Hillside at Lorson Ranch Traffic Impact Study

Engineering Review

January 17, 2022

Figure 15. Build Out Total Traffic Volumes (AM Peak Hour)

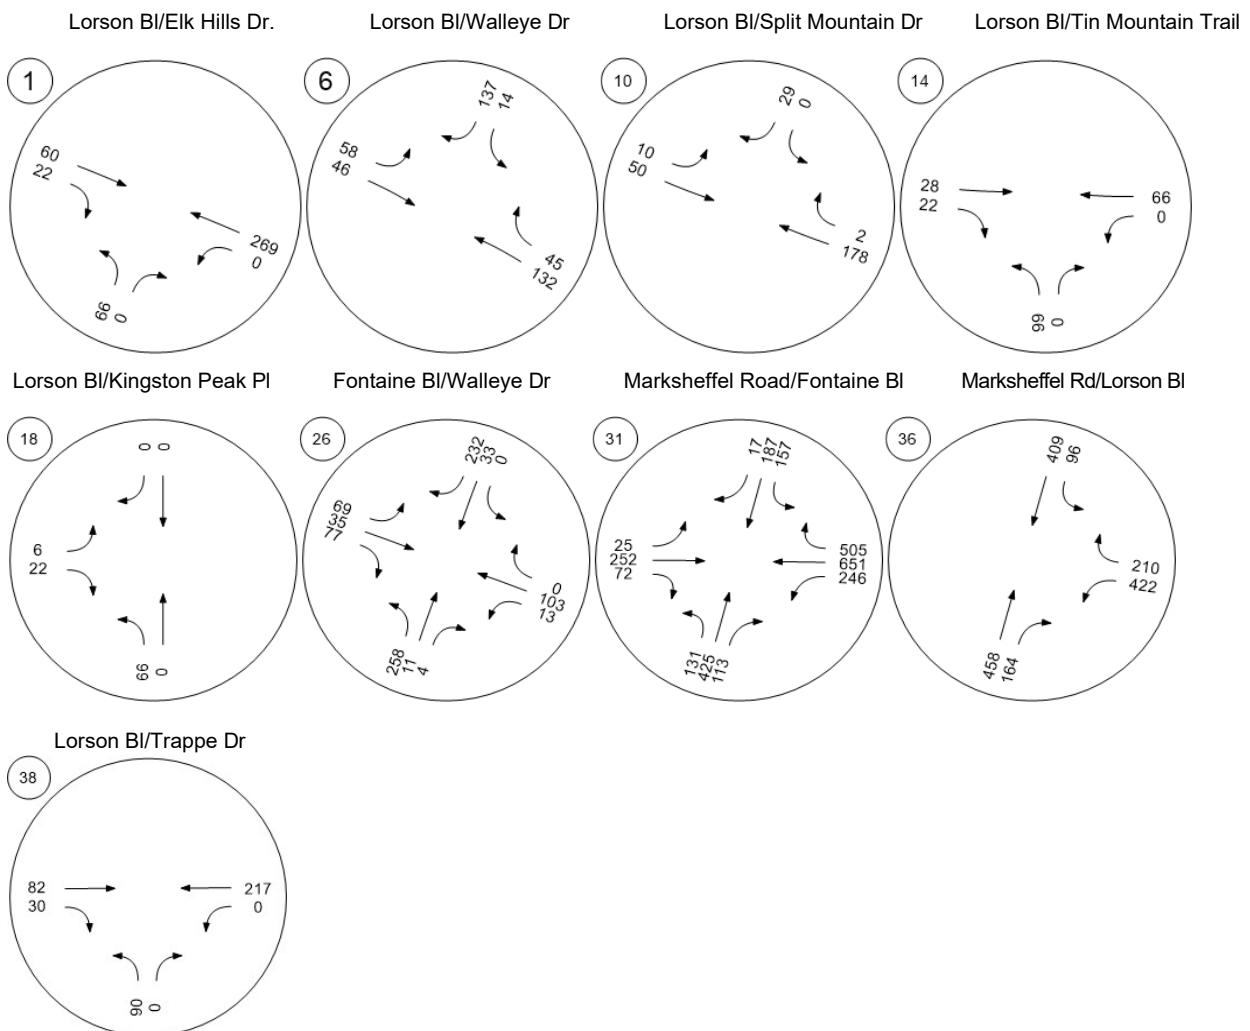
Corvallis traffic from west?

Figure 16. Build Out Total Traffic Volumes (PM Peak Hour)

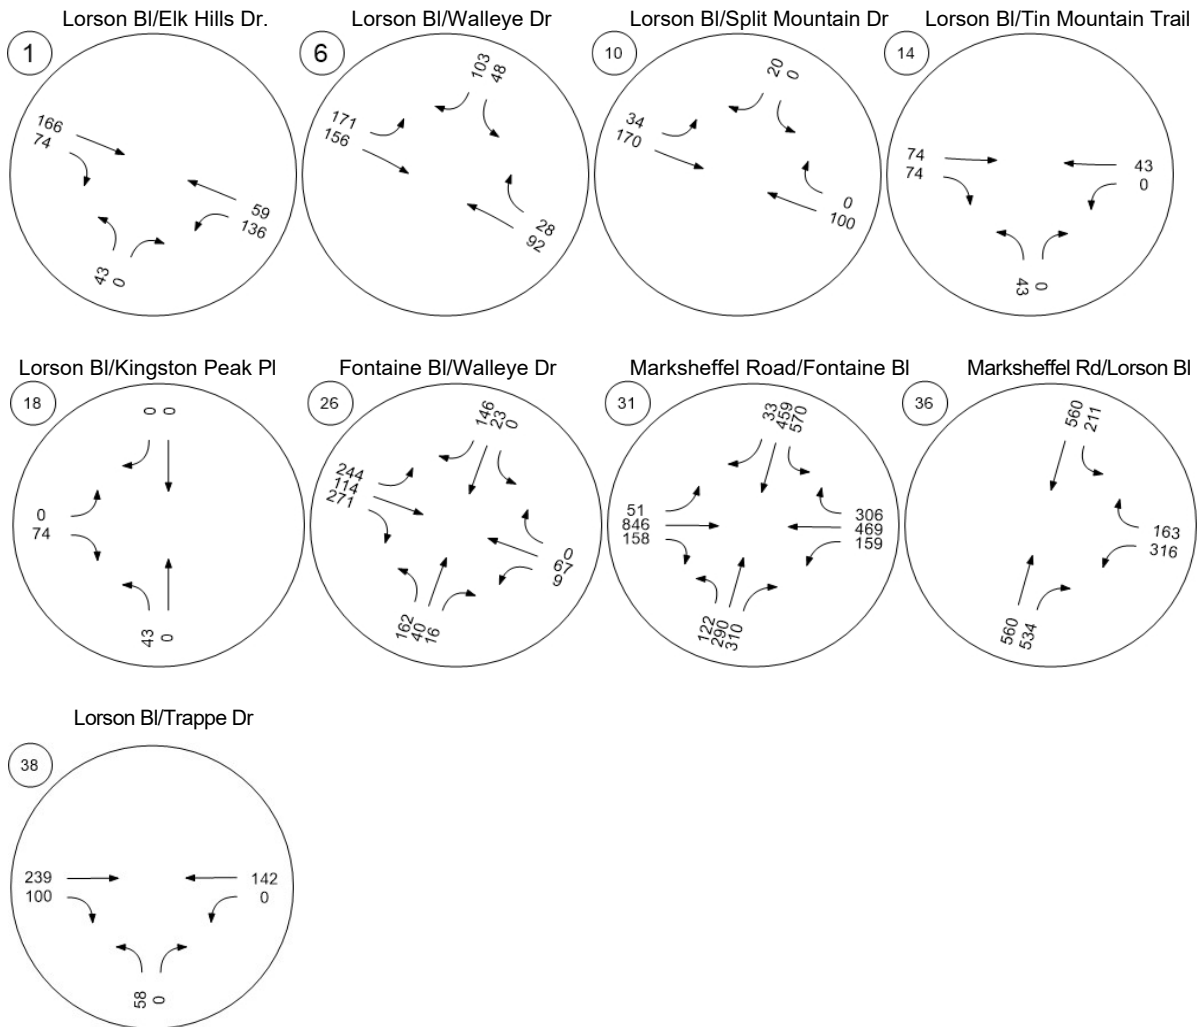
Label major street names

Figure 23. Horizon Total Traffic Volumes (AM Peak Hour)

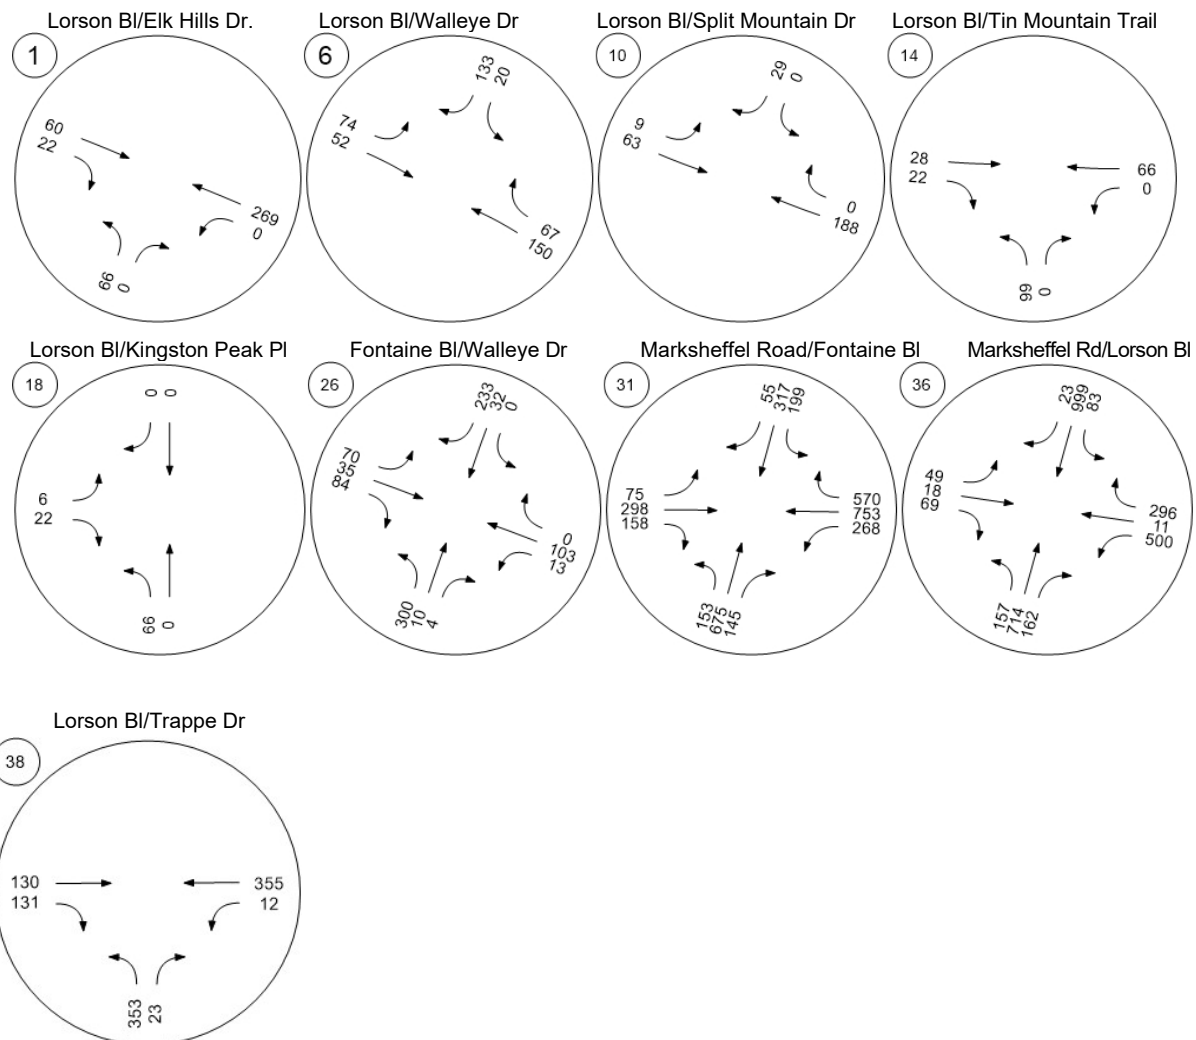
Label major street names
